Our Ref: SDNP/20/03305/ADJAUT
Contact Officer: Stella New
Tel. No.: 01730 819216

Neighbouring Authority Consultation

Proposal: Adjacent Authority Consultation from Arun DC, Case Ref: A/109/20/RES - AMENDMENTS RECEIVED to Approval of reserved matters following outline consent A/99/17/OUT for 175 No dwellings & associated infrastructure. This application may affect the setting of a listed building, may affect the character & appearance of the Angmering Conservation Area & falls within Strategic Site SD9, CIL Zone 1 (Zero Rated).

Address: Land South of Water Lane , Angmering

PARKLAND EDGE

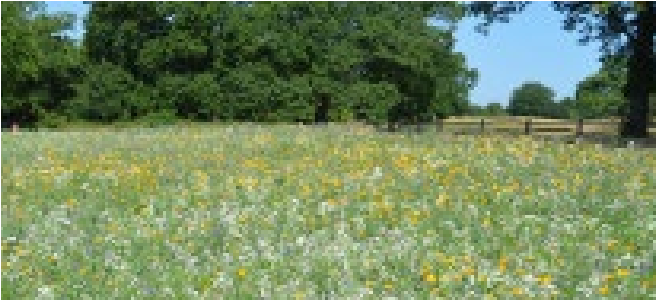
The revised landscaping masterplan also annotates the eastern boundary by including depth measurements of the planted buffer which range from 7m to 15m. However, the measurements include the existing boundary hedge, as well as what appears to be a pedestrian access running the western edge of the buffer and, in some cases, what appear to be sections of private garden. No measurements are provided of the narrowest sections of the buffer where the visitor car parking spaces are provided.

The only point where the LVIA considers the visual impacts on the National Park is in section 5.5 Landscape Effects, where impacts during construction (and presumably at year 1) are considered to be 'moderate adverse;' however reduced to 'negligible' by year 15 due to the provision of the 5.5m-wide buffer along the eastern boundary of the site, which "once matured" would "significantly screen" views from the east. No visual montages are provided, and no consideration is given to the effectiveness of the landscape buffer, either generally or more specifically in winter vs summer months.

It is the view of the Authority that the design of development generally should be of a high standard so as not to require screening; however, in this case it is accepted that a woodland buffer is necessary to mitigate the impacts of development on the National Park setting. However, the buffer as proposed is insufficient to provide adequate screening the development, let alone support multifunctional recreational or wildlife corridor benefits. To achieve the level of screening necessary, and given the scale and height of the new dwellings (in particular the large three-storey apartment block comprising units 159-167) the buffer should provide a wooded belt of a sufficient width/depth of local native tree and scrub species to ensure minimum/glimpsed views of the development, and to assist the scheme in achieving biodiversity net gain.
